Subject: RE: Planning Consultation on: EP/115/20/PL

Engineers Comments Regarding Surface Water Drainage

Application No: EP/115/20/PL
Registered: 2nd October 2020
Site Address: 4 Beachlands Close & land rear of 18 Montpelier Road East Preston BN16 1JZ
Grid Reference: 507222 102368
Description of Works: Side extension, loft conversion & detached garage to existing dwelling & erection of 2 No semi detached houses. This site is in CIL Zone 4 & is CIL Liable as new dwellings.

18 BEECHLANDS COURT, EAST PRESTON, BN16 1JZ	
Client	Description
c/o RSP ARCHITECTS LTD	NEW SEMI-DETACHED HOUSE PLANS AND ELEVATIONS

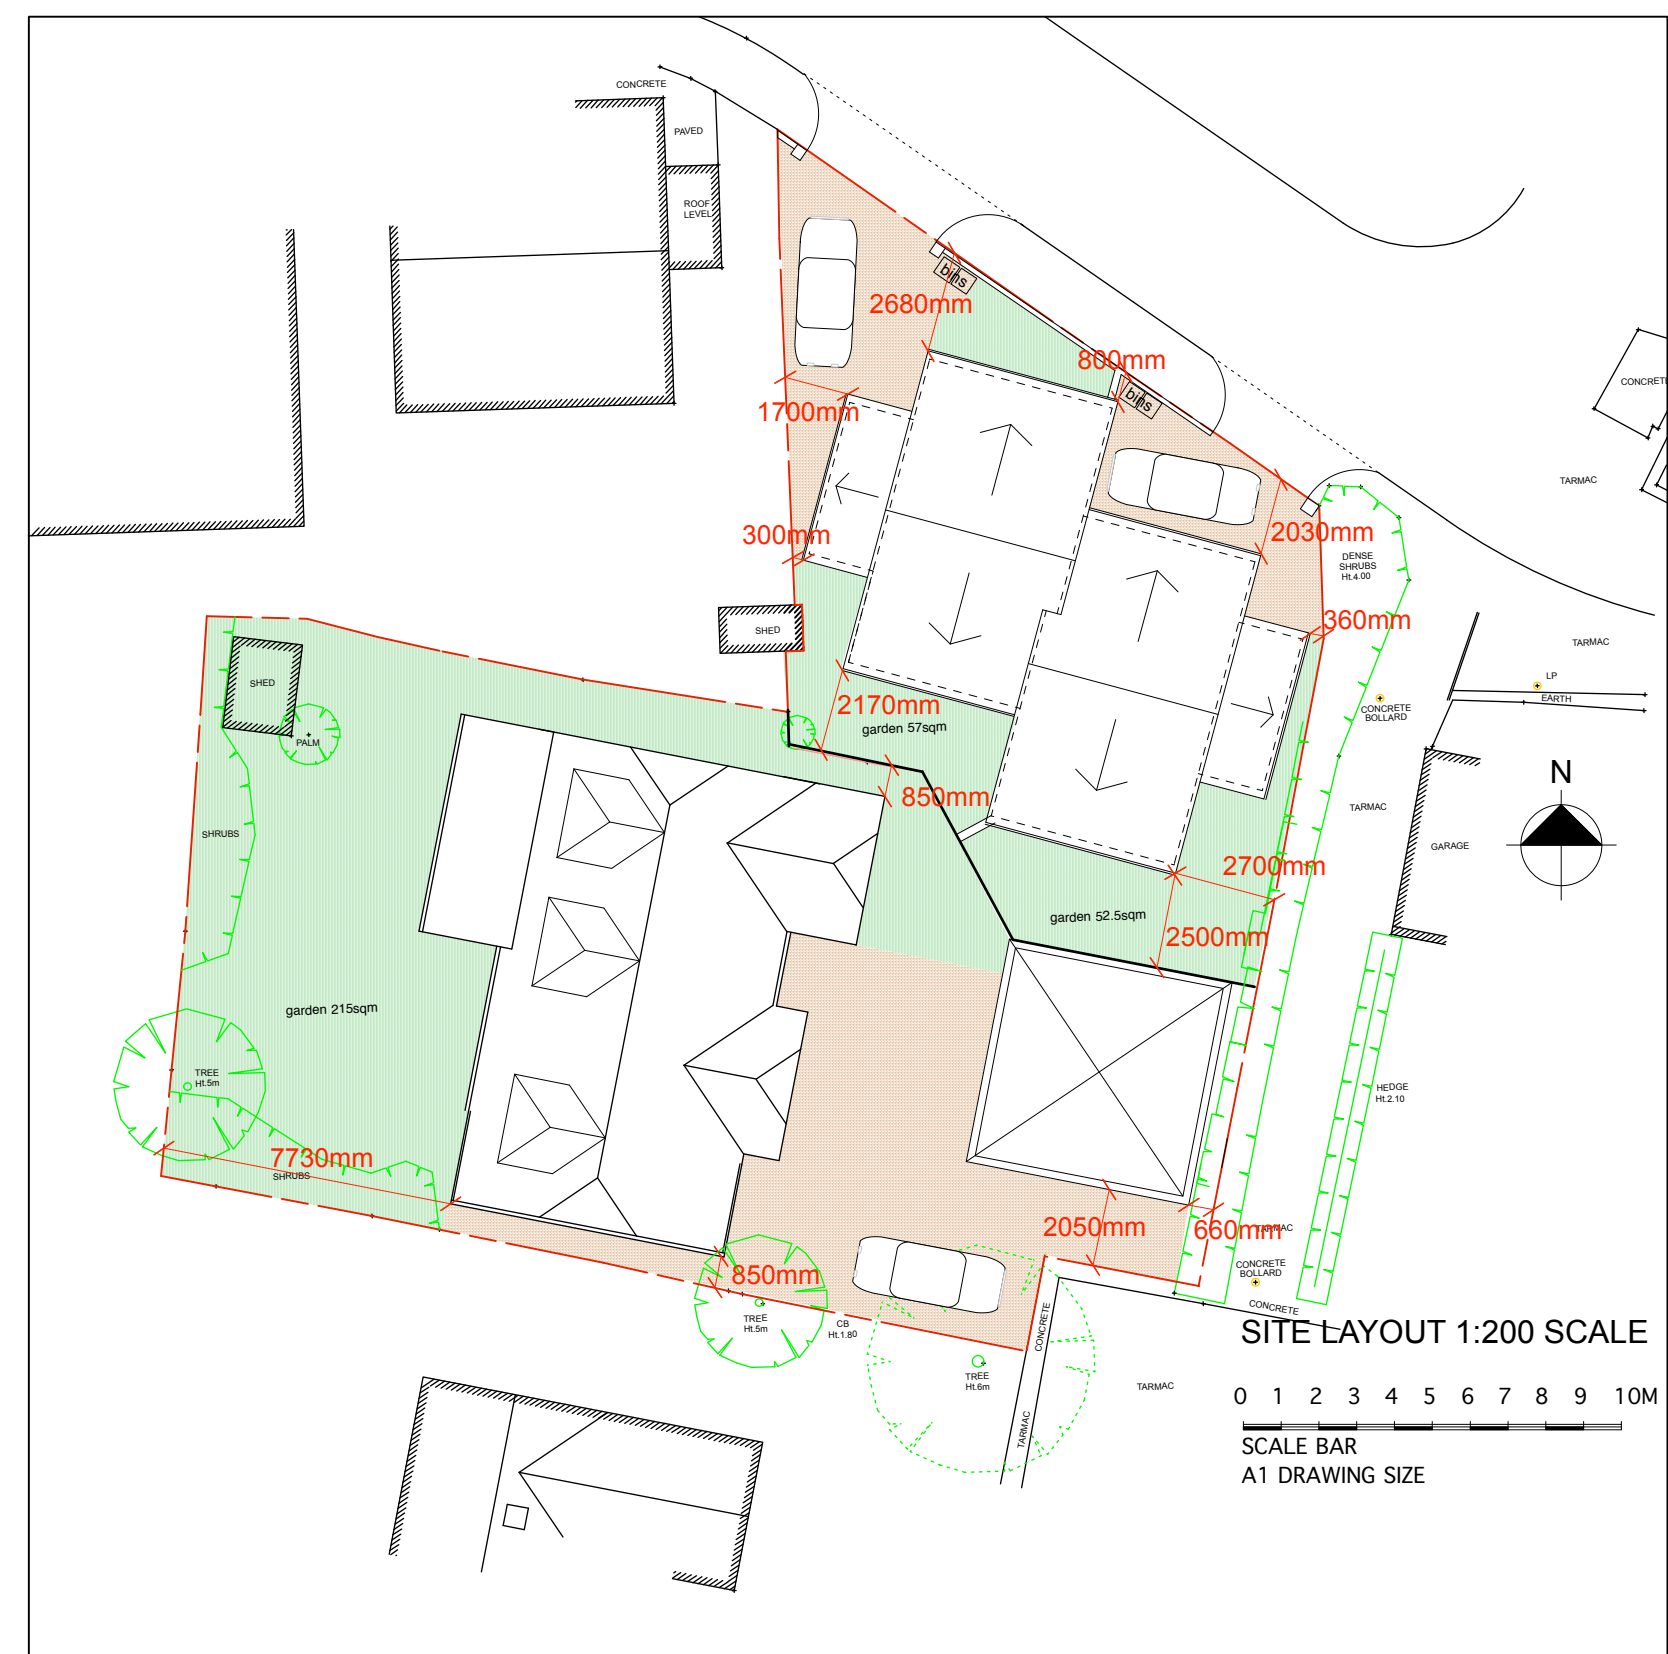
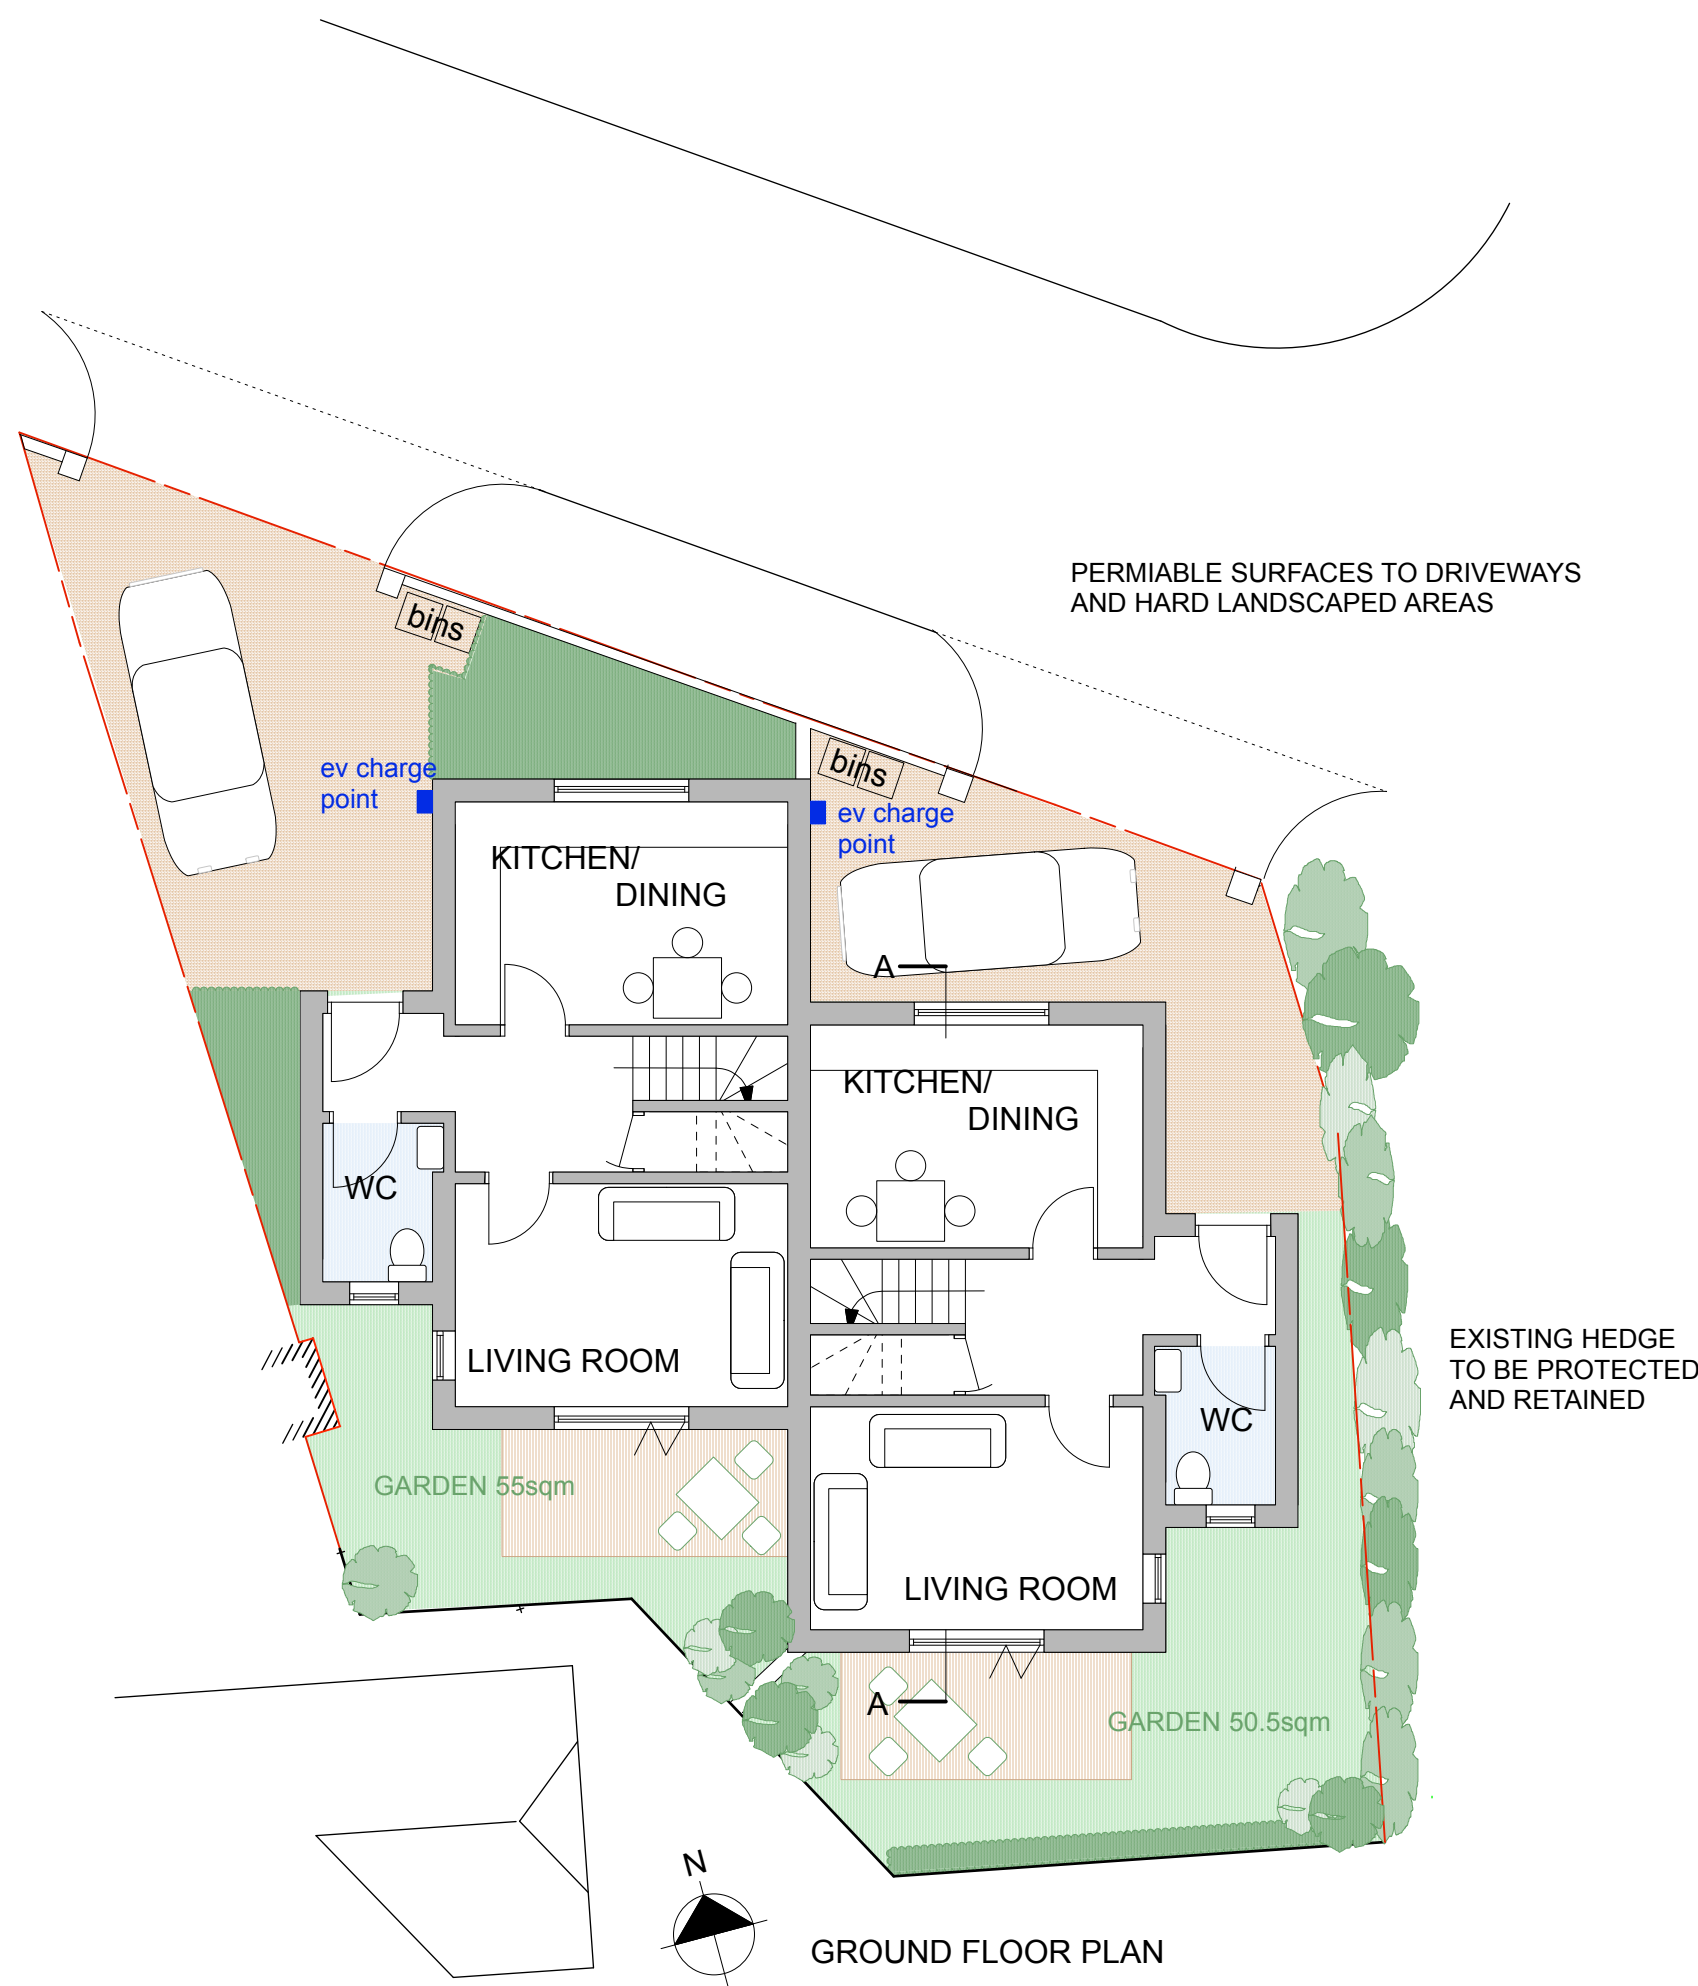
In this case, it is clear from the dimensions shown on the site layout that it will not be possible to locate soakaways within the boundaries of either of the semi-detached properties. It is unlikely that a soakaway serving all of the proposed buildings (including the garage) can be located between the existing bungalow and the new garage (not

certain as dimensions not provided). There is a slim possibility that a soakaway could be placed within the rear garden of the existing bungalow, however this would be a challenge, would require a relaxation of our requirements regarding the proximity to the boundary and would result in the undesirable outcome of both semi-detached properties being drained outside of their curtilage on to someone else's property.

In order to remove my objection the applicant will need to supply winter groundwater monitoring, infiltration testing and a drainage design that shows that it is possible to meet our requirements and drain surface water from the site without increasing flood risk elsewhere.
